DPIRD Fisheries

28 October 2024

Re: **Modification 1 Tilbuster Solar Farm Modification (SSD-9619-Mod-1)**

APPENDIX 1: GENERAL LAYOUT OF DEVELOPMENT

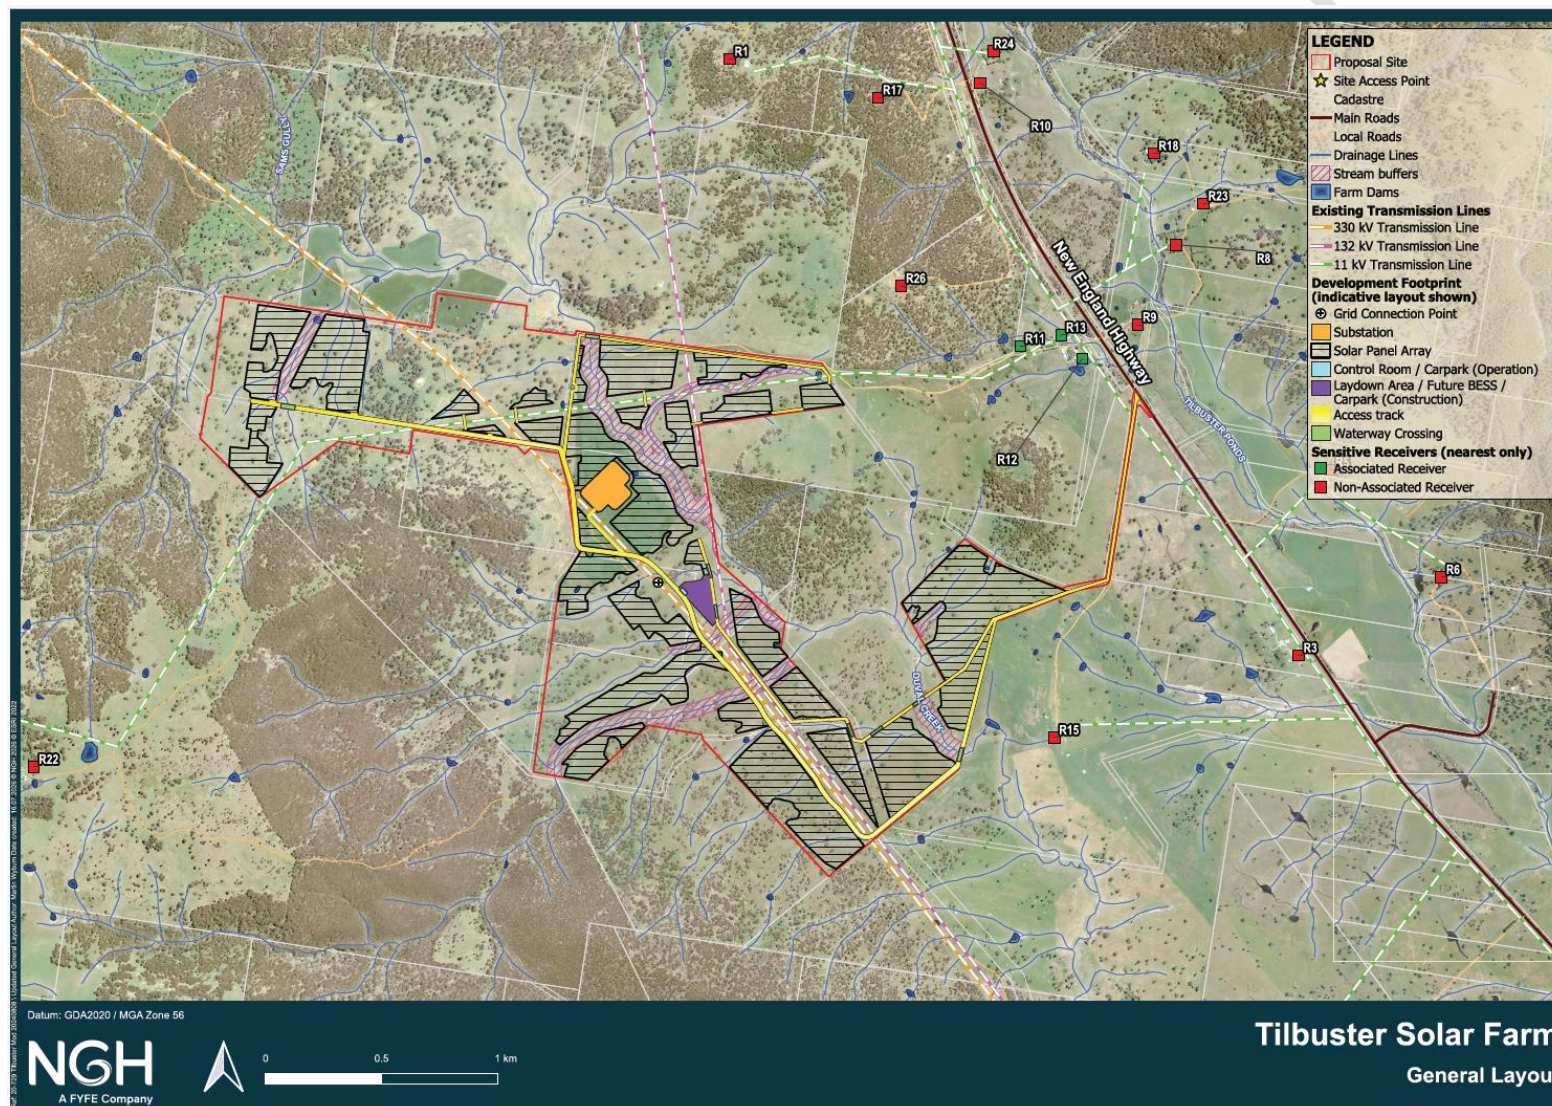
Stream buffers are to be established and maintained as per Appendix A.1. Updated General Layout of the Tilbuster Solar Farm Modification Report. There is to be no disturbance or development within established stream buffers except for the construction of approved watercourse crossings and access tracks, or measures outlined within the Biodiversity Management Plan.
